Engineers Comments Regarding Surface Water Drainage

Application Reference:	Y/71/25/DOC	Reviewer Reference:	ADC/EXT4
Planning Officer:	Simon Davis	Date of Review:	17/03/2026
Site Name:	Land at Stakers Farm North End Road Yapton		
Application Description:	Approval of details reserved by condition imposed under Y/44/17/OUT relating to condition 18-updated copy of management manual for SuDS system.		
Assessment Number:	2 of 2

Application Reference: Y/71/25/DOC Site Name: Land at Stakers Farm North End Road Yapton	Initial Issue Date: 29/12/2025 Issue Date: 17/03/2026 Reviewer Reference: ADC/EXT4
--	--

Job Title LAND AT STAKERS FARM YAPTON		
Drawing Title SW MAINTENANCE PLAN (70 UNITS SCHEME)		
Client DANDARA LIMITED (SOUTHERN)		
Scale 1:500 @A1	Date JAN 26	Designed AK
Drawn AK	Checked BO	Approved BO
Job No 19-156	Drawing No YAP-130-090	Rev A

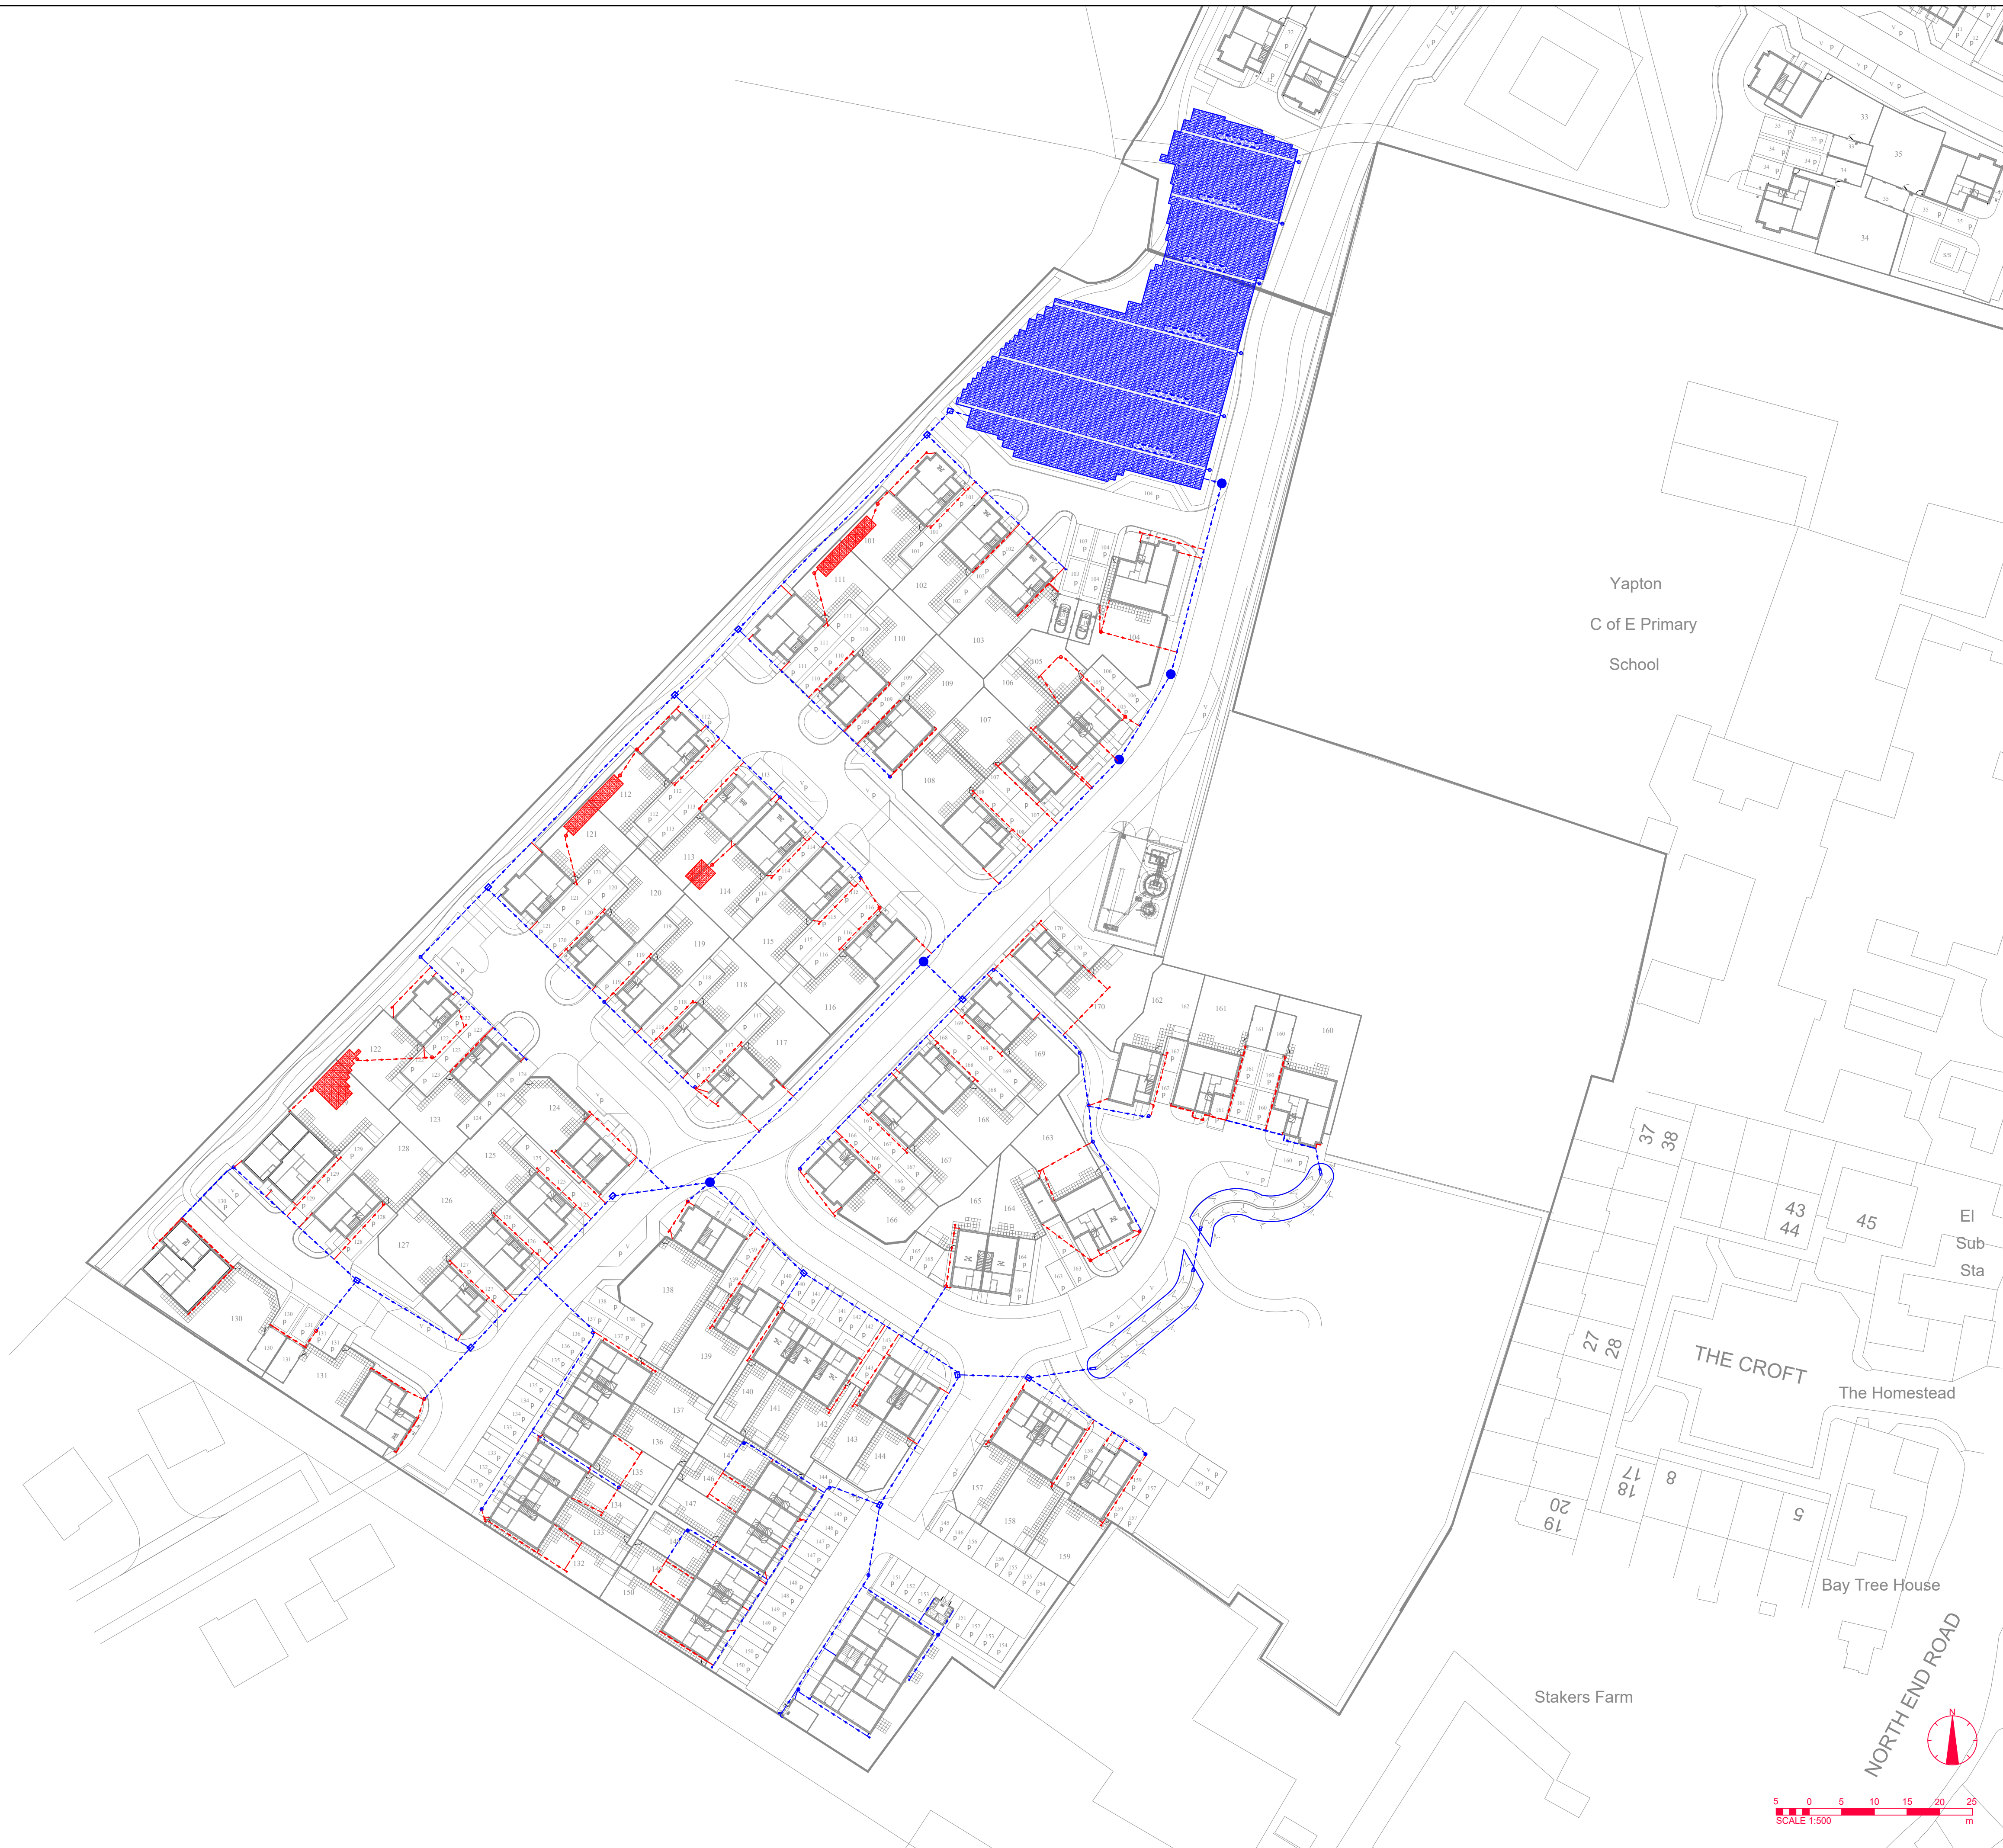
construction details need to be included		
3.	Please provide a plan showing maintenance responsibility should be included in the report	Additional drawing YAP-130-090 provided that differentiates the responsibility between management company and respective householders.	Thank you for providing this but please add a key to this drawing to identify which the red colour and blue colour drainage relates to please
